From: Simon Davis
Sent: 26 April 2022 11:30
To: 'Lisa Jackson' [REDACTED]
Subject: RE: Planning Re-Consultation on: Y/32/22/DOC

From: Laura Gibbons [REDACTED]
Sent: 26 April 2022 10:02
To: Planning.Response [REDACTED]
Cc: Simon Davis [REDACTED]
Subject: RE: Planning Re-Consultation on: Y/32/22/DOC

Engineers Comments Regarding Condition 8

Drainage Construction Details Proposed Basin Detail

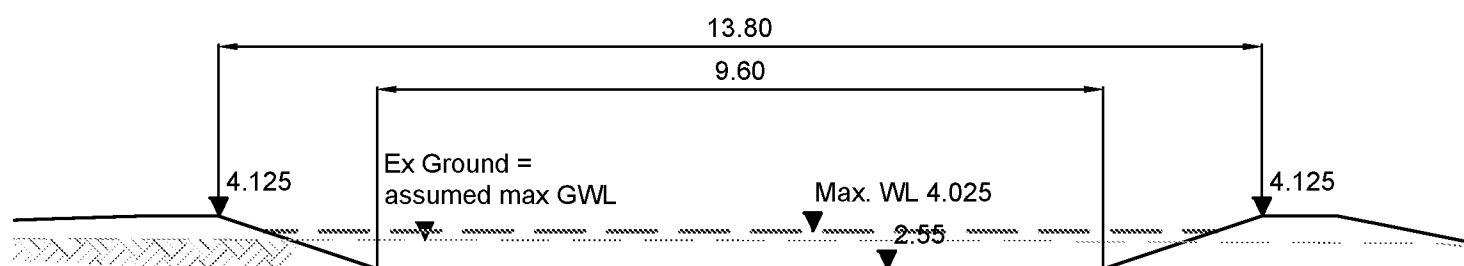
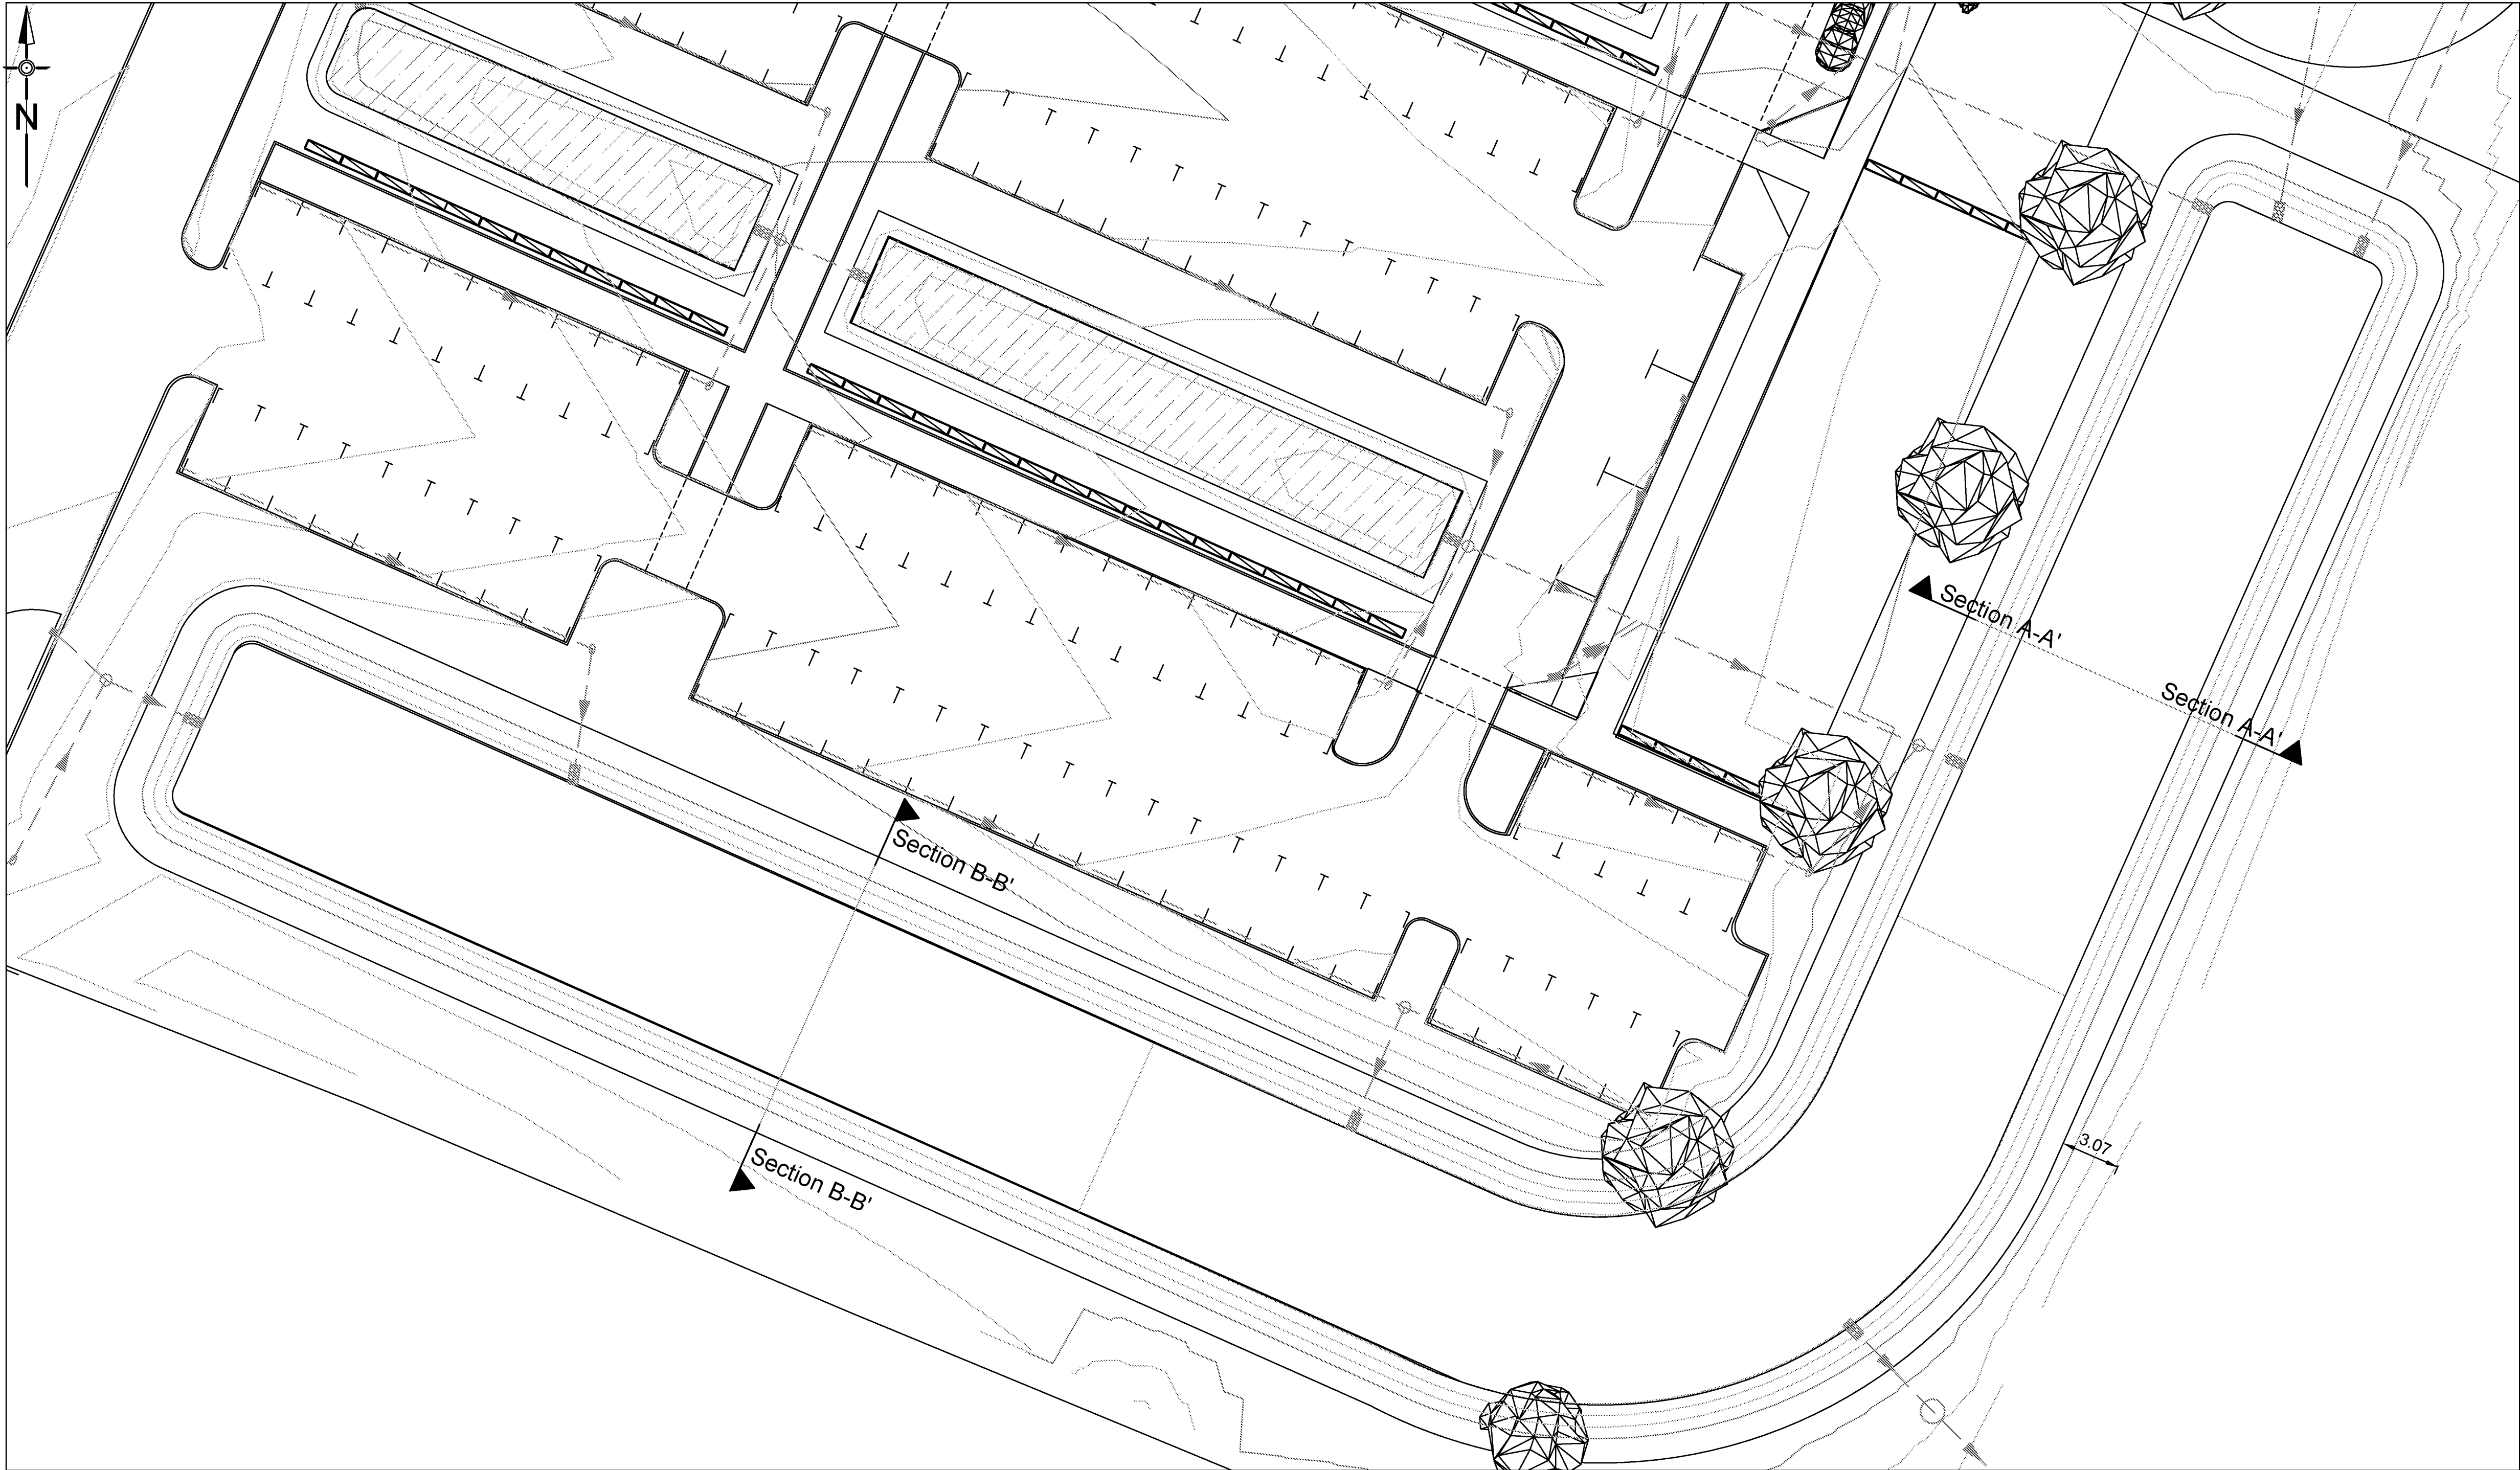
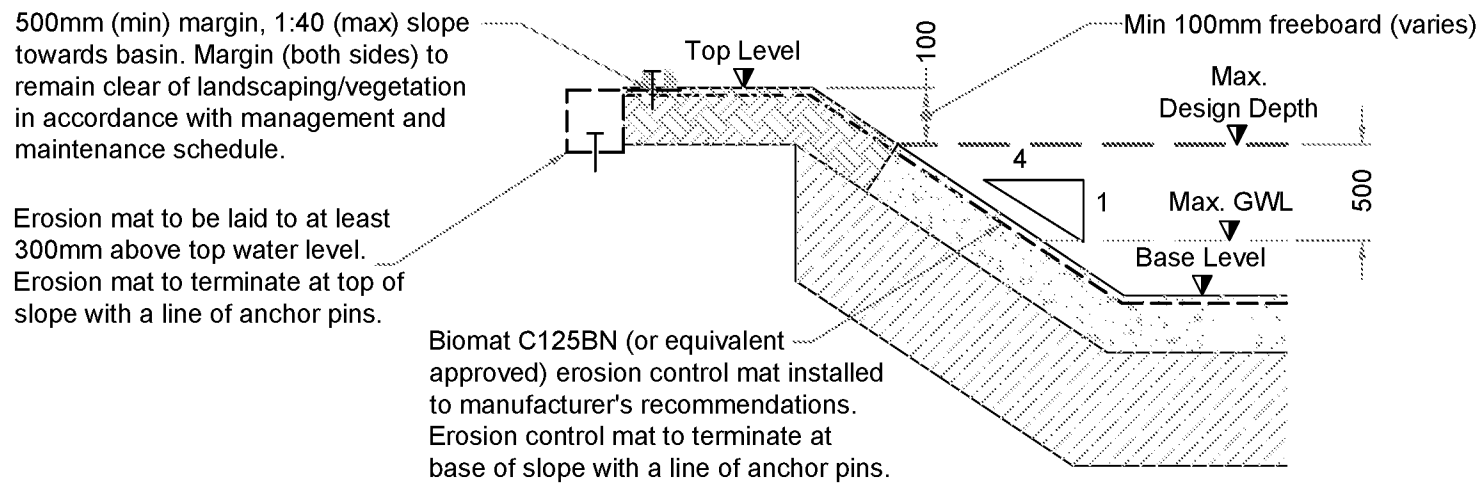
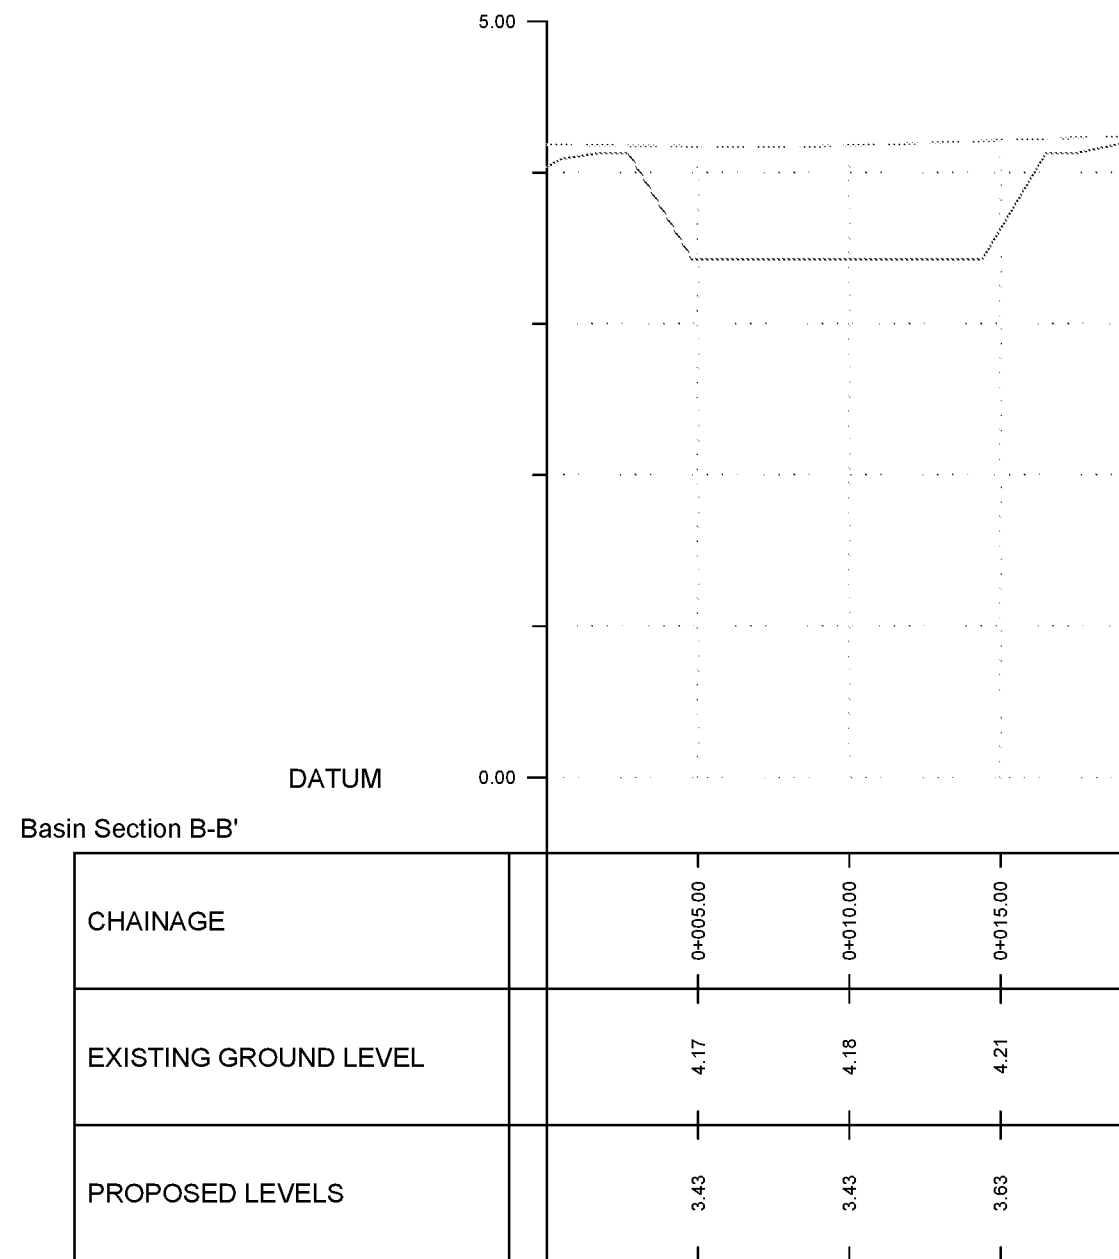
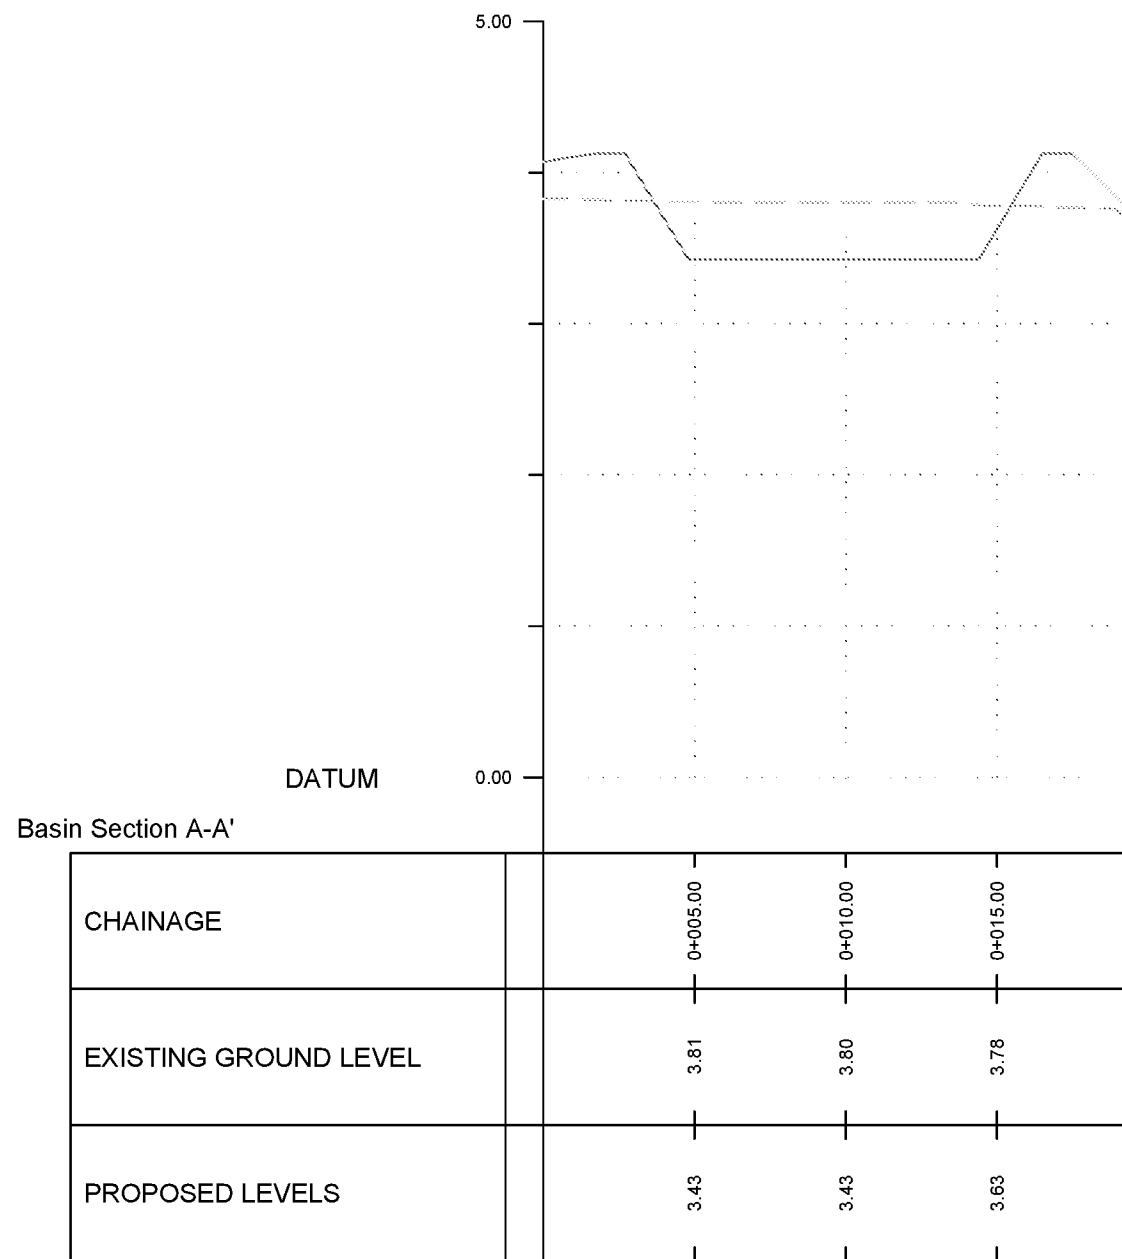
9. Please supply site specific construction details of the attenuation basin, showing invert level, top of bank level, width at bed and width at bank. Please see enclosed basin detail drawing 13591-CRH-XX-XX-DR-C-5310 Revision P1. To be reviewed once principals are agreed.
